Online Comment

Application H15-0557-23
Location Judy Cross Barn Watergate Quadring PE11 4PY
Proposal Details of wildlife survey, contamination of land or pollution of controlled waters, foul/surface water disposal, landscaping & tree planting, proposed boundary treatments, design of external doors & door frames, window frames and proposed roof light(s). (Conditions 3, 4, 5, 6, 7, 8, 9 and 10 of H15-0100-21)

Name Sue Armour
Address Team Leader Environmental Protection SHDC

Date Submitted 08-11-23
For/Against Comments

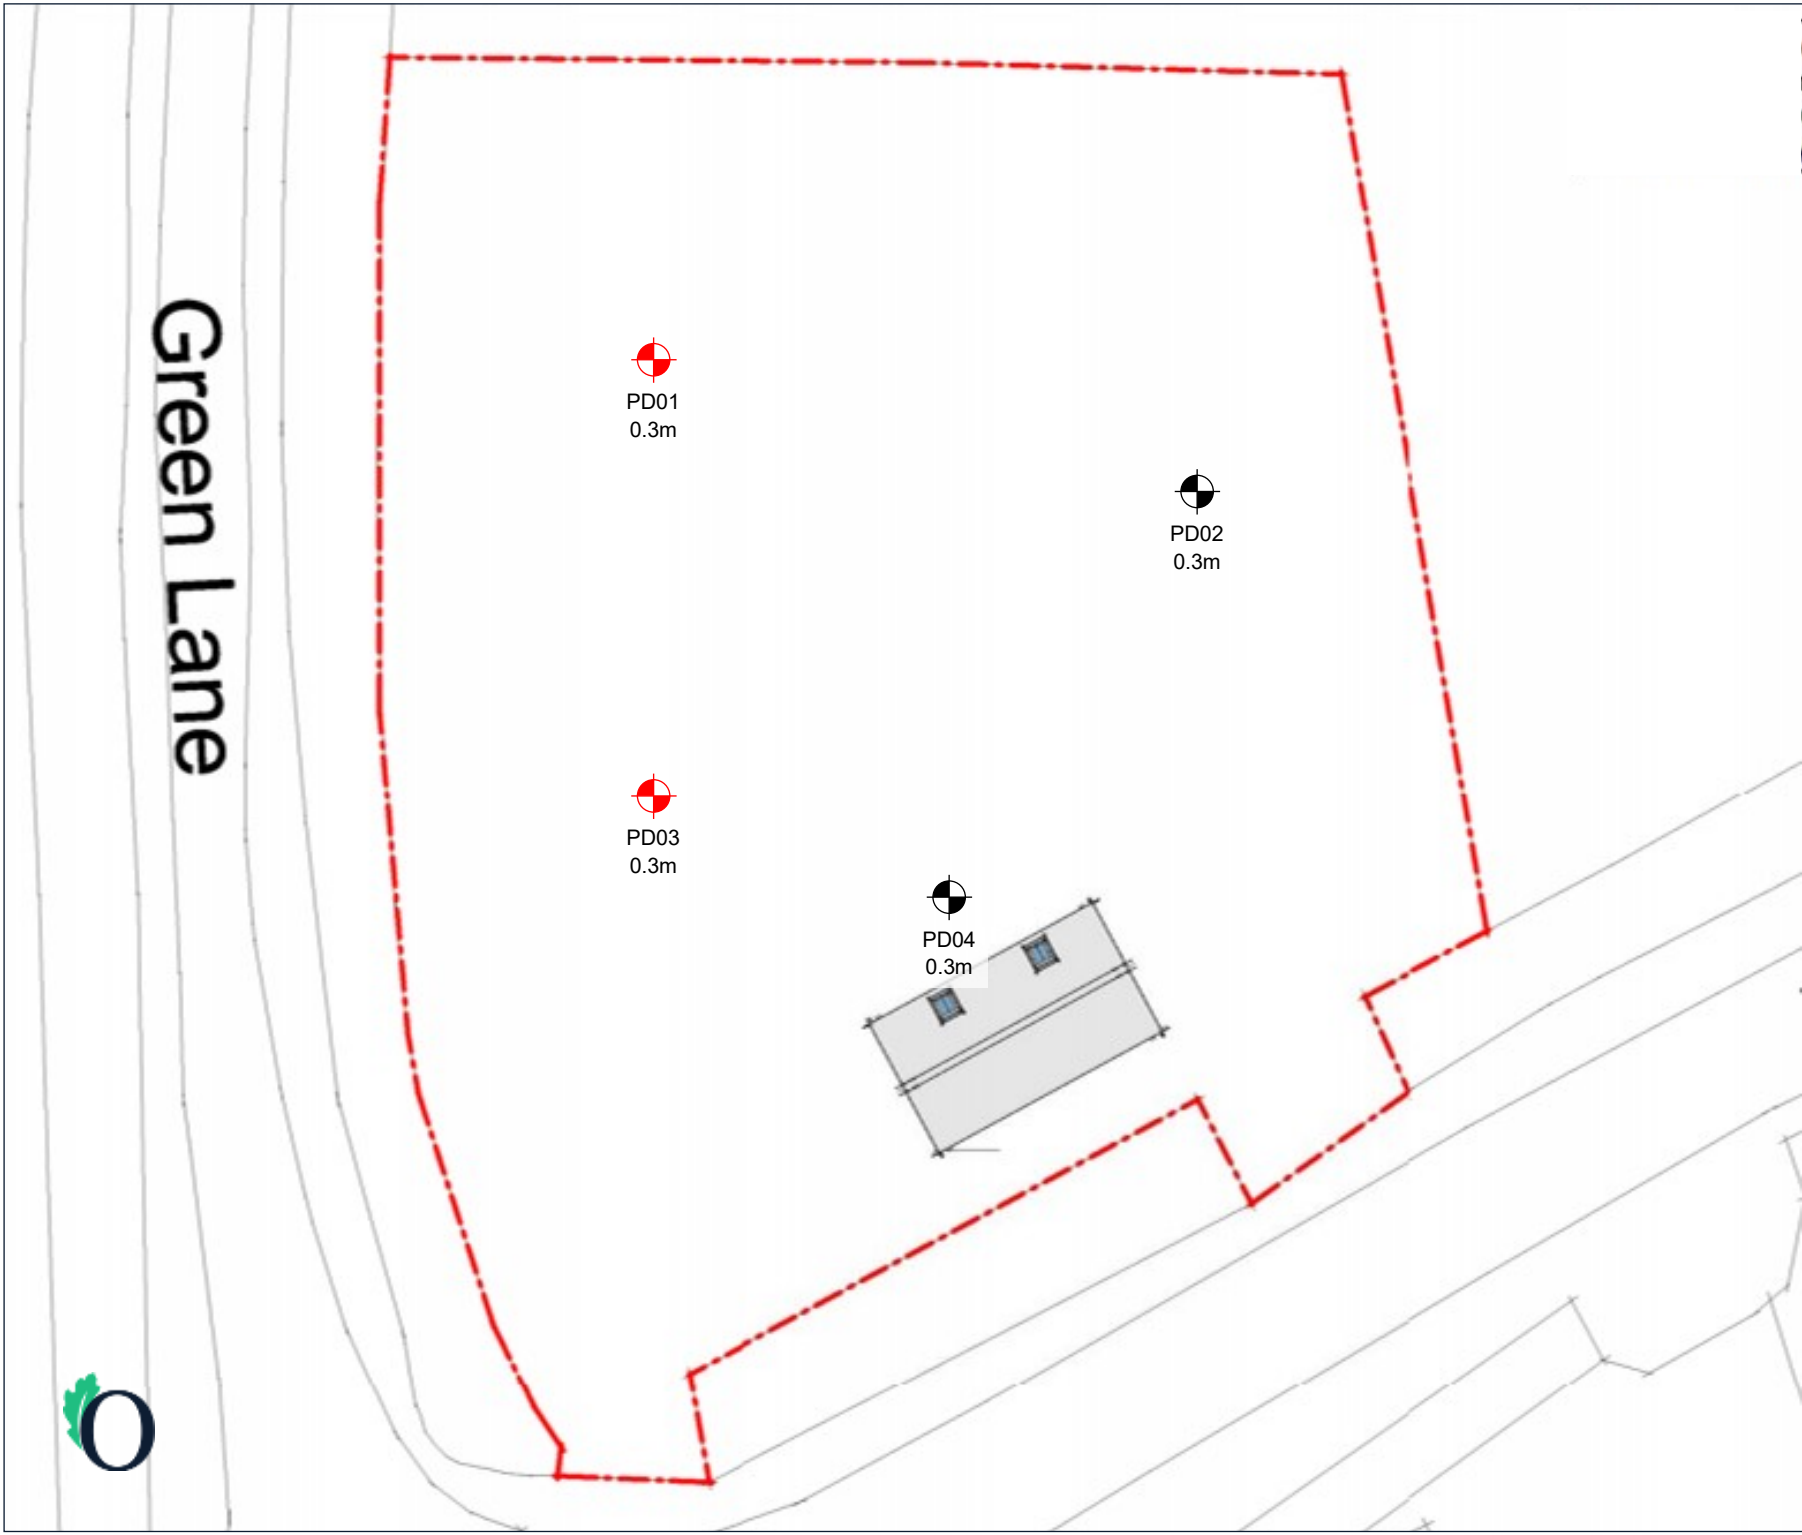
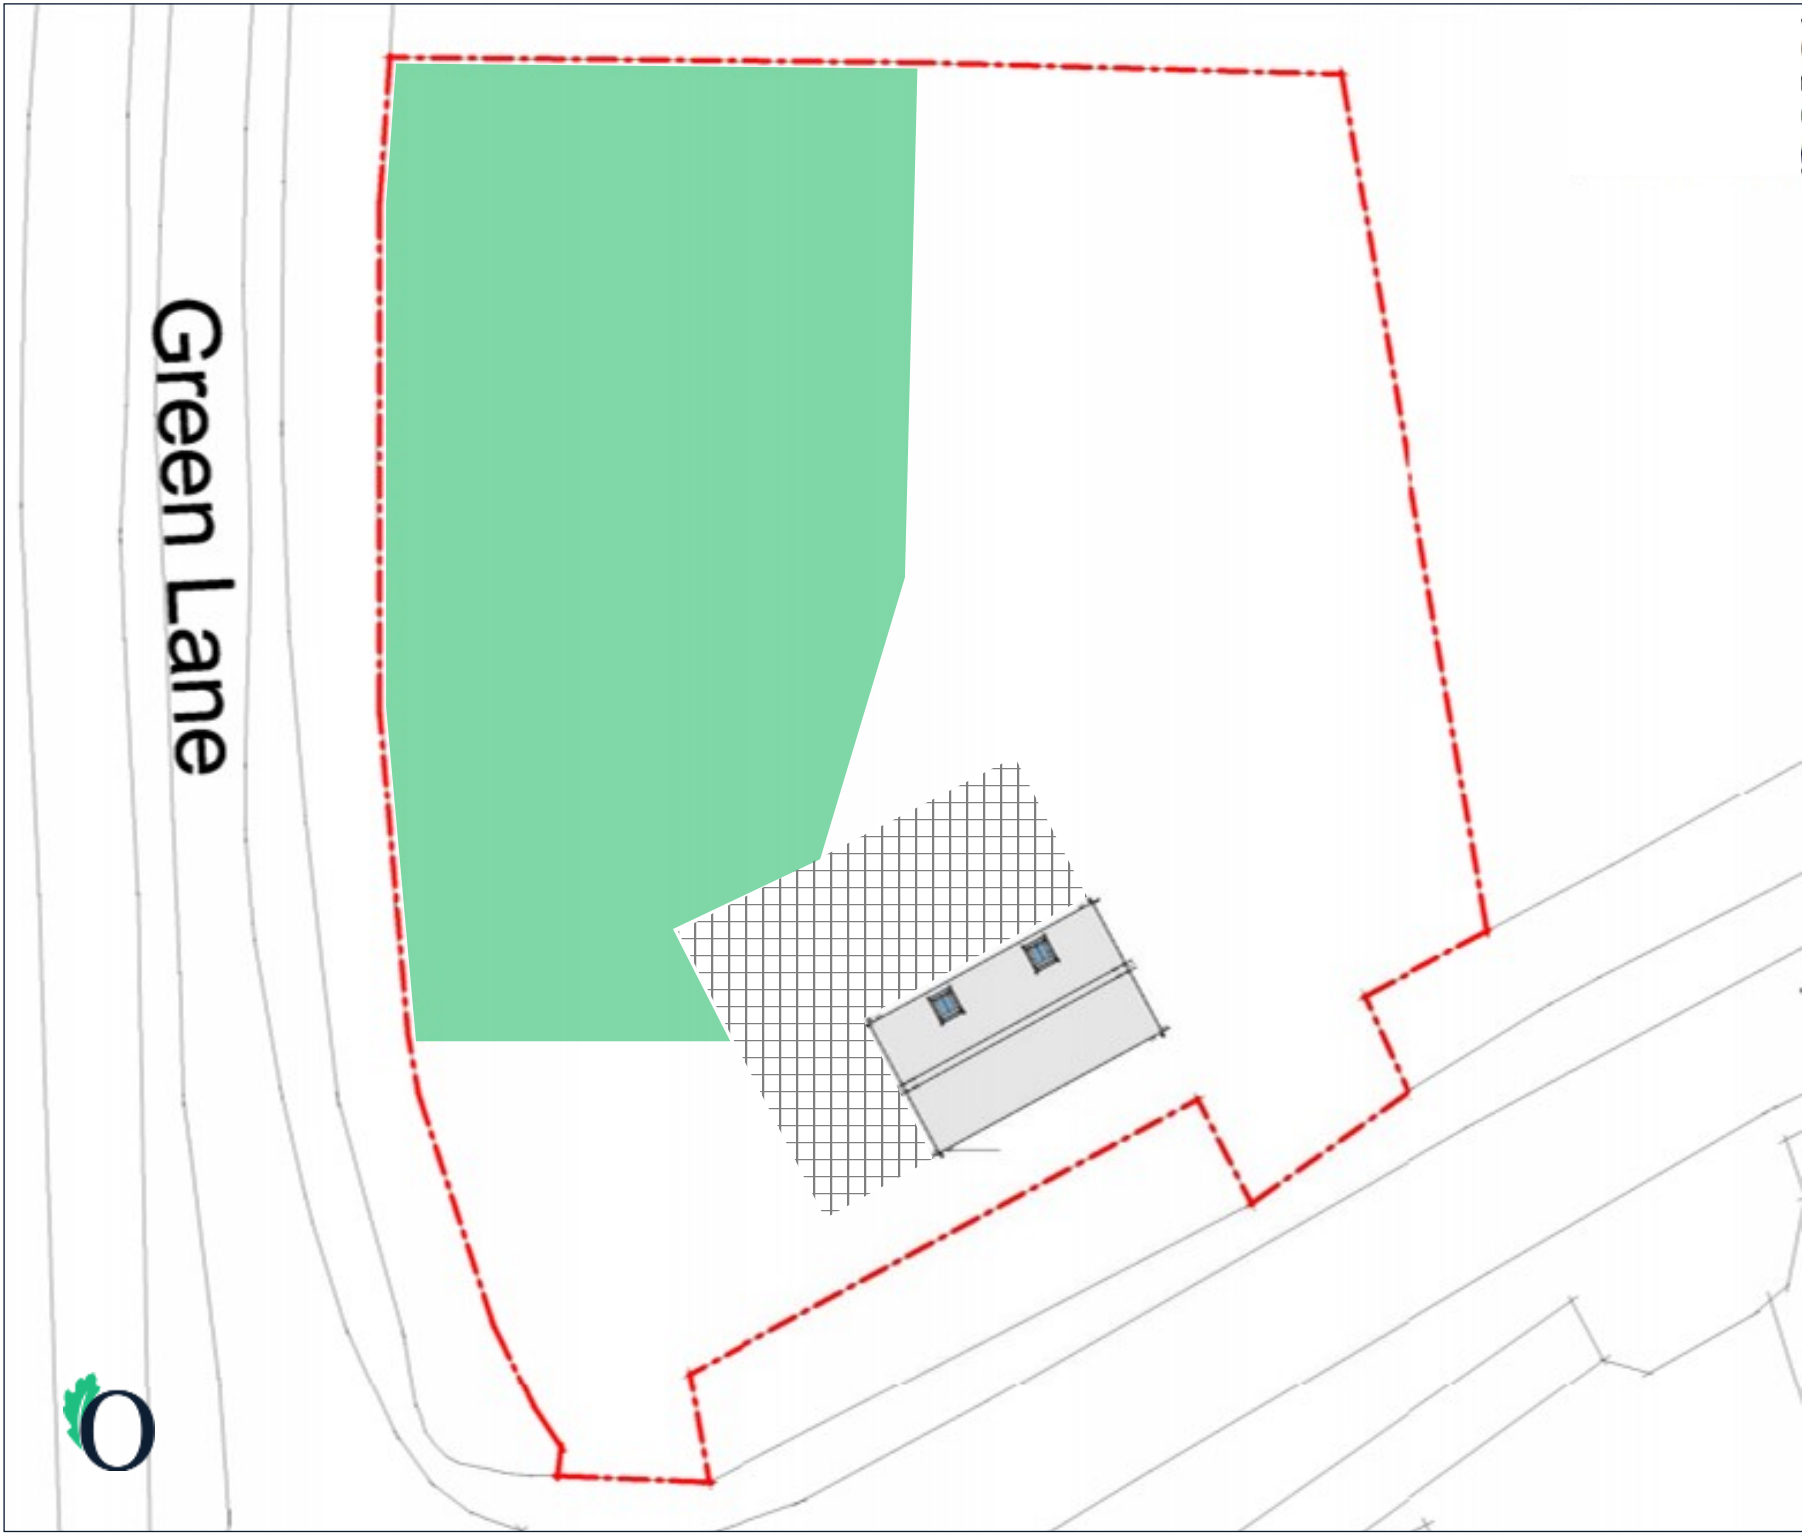
Two options were discussed - breaking the pathway by either clean cover or a physical barrier, with 600mm clean cover suggested as the consultants preferred solution. In theory, either option is acceptable, however I feel that there are too many uncertainties at this point to agree the remediation strategy proposed in section 5.2.

In particular, there is no rationale to explain how the area to be covered by the remediation has been determined. There is no physical identifier to delineate either the area or depth affected. The report assumes that soil below 300mm and outside of the proposed remedial area does not contain elevated levels of determinants, but there is no evidence to support this decision.

I consider that either a wider remediation, or further sampling to delineate the area is required.
